AA TAKLA ENGINEERING, PLLC Consulting. Design. Efficiency.

Project: LOT# 41 Purfoy Place
Location: Furquan - Vanna, NC
Date: 2/10/22
Company: _____
Care Of: Luis Lopez

Project: Lot # 41 Purfoy Place
Location: Fuquay-varina
Date: 3/4/22
Company: _____
Care Of: Luis Lopez

CRAWL FOUNDATION PLAN 'A'
 SCALE: 3/16" = 1'-0"

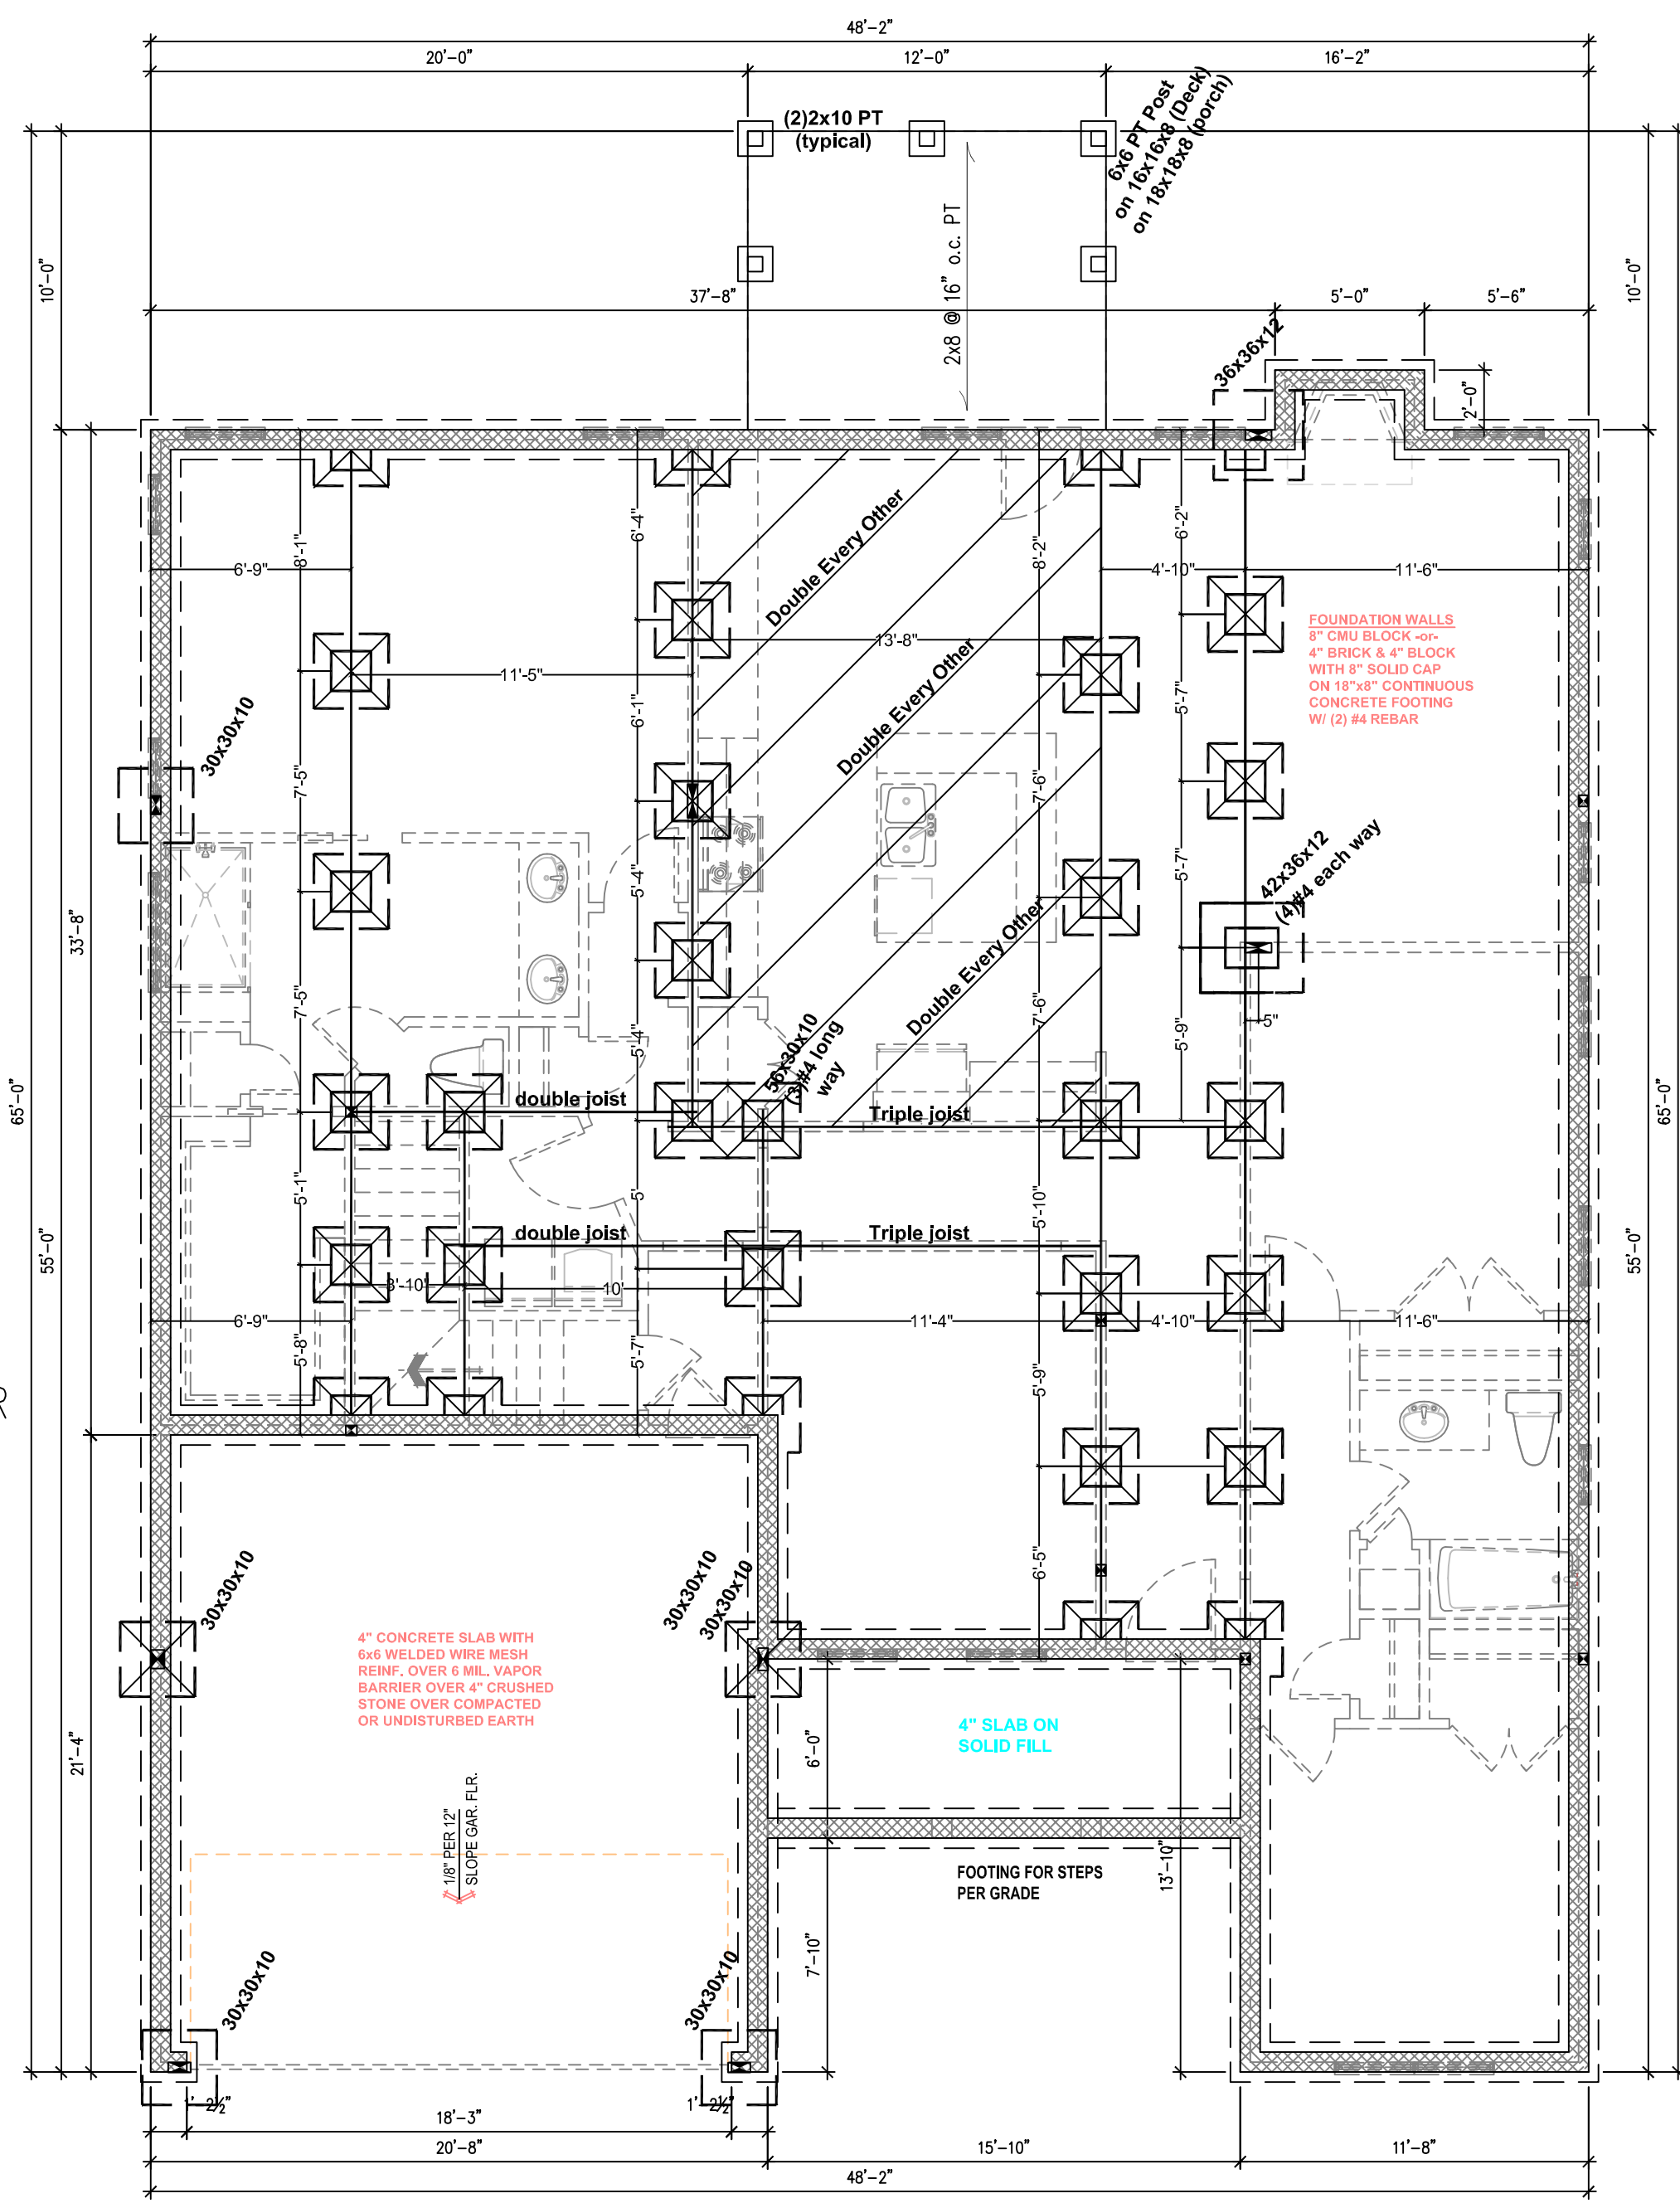
As Requested A. Takla visited the site and observed the footing trenches of the house and found adequate per plan, meet NCRC-2018
O.K. TO place # 57 stone for Deep Trenches.

AS REQUESTED A. Takla prepared THIS report to address THE Footings Lacks 2" projection) repairs and found adequate. In-place Dowels and Additional footing are adequate
O.K TO POUR
